Ribble Valley Borough Council  
Development Control

Application no: 3/2019/0954

Address: Primrose Mill, Primrose Road Clitheroe

Proposal: Conversion of Existing Mill complex to provide 25 residential apartments

PROPOSED SITE PLAN

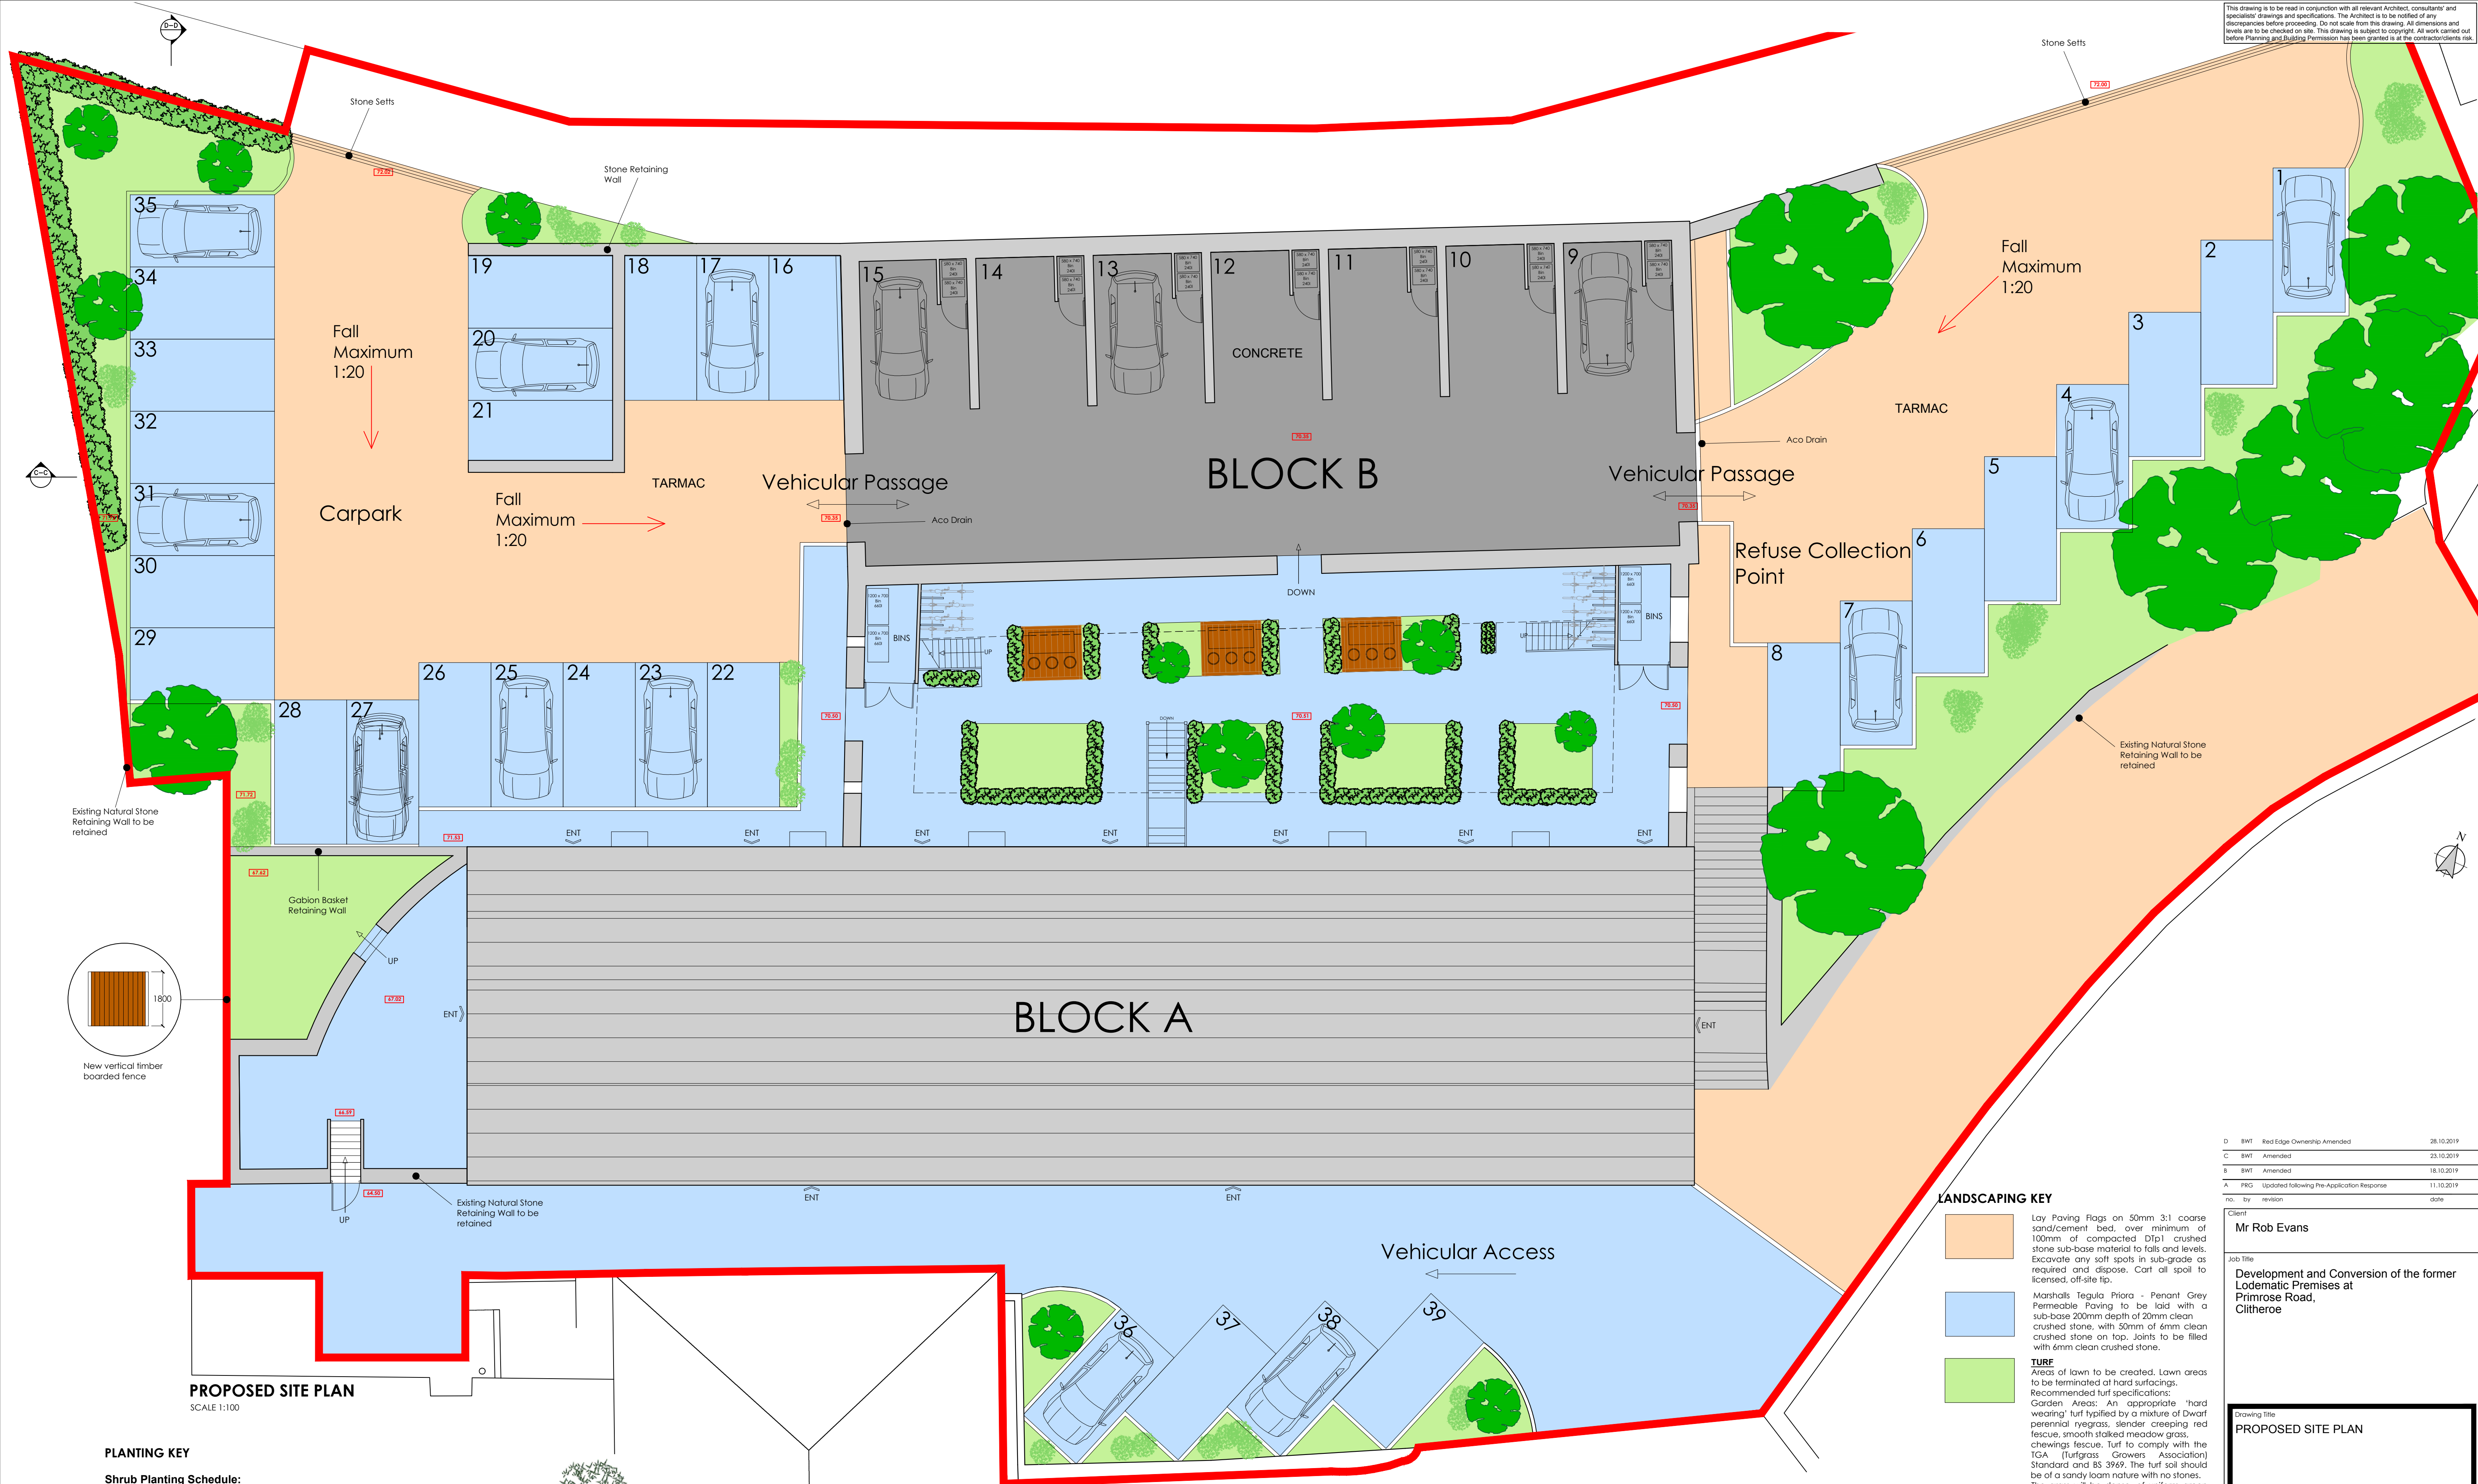
1 In previous consideration of the various applications for this site a swept path analysis for refuse vehicles from Woone Lane turning into and servicing the site has been requested. This level of detail has not been provided as part of the application submission. The applicant will need to demonstrate that this type of vehicle can enter and leave the site in forward gear and provide safe access to the refuse collection area within the site

2 Para 4.5 of Appendix A of the Transport Statement submitted with the application refers to the upgrading of the access to the site from Woone Lane. This element has not been included with the existing application and is considered necessary to bring the access up to an appropriate standard for a shared pedestrian / vehicular use.

3) Access to the parking spaces numbered 36 – 39 are restricted and will require the vehicles to reverse out of the site in order to approach Woone Lane in a forward gear. Any reversing movements in this area are likely to be problematic – visibility and adverse gradients - and should therefore be avoided.
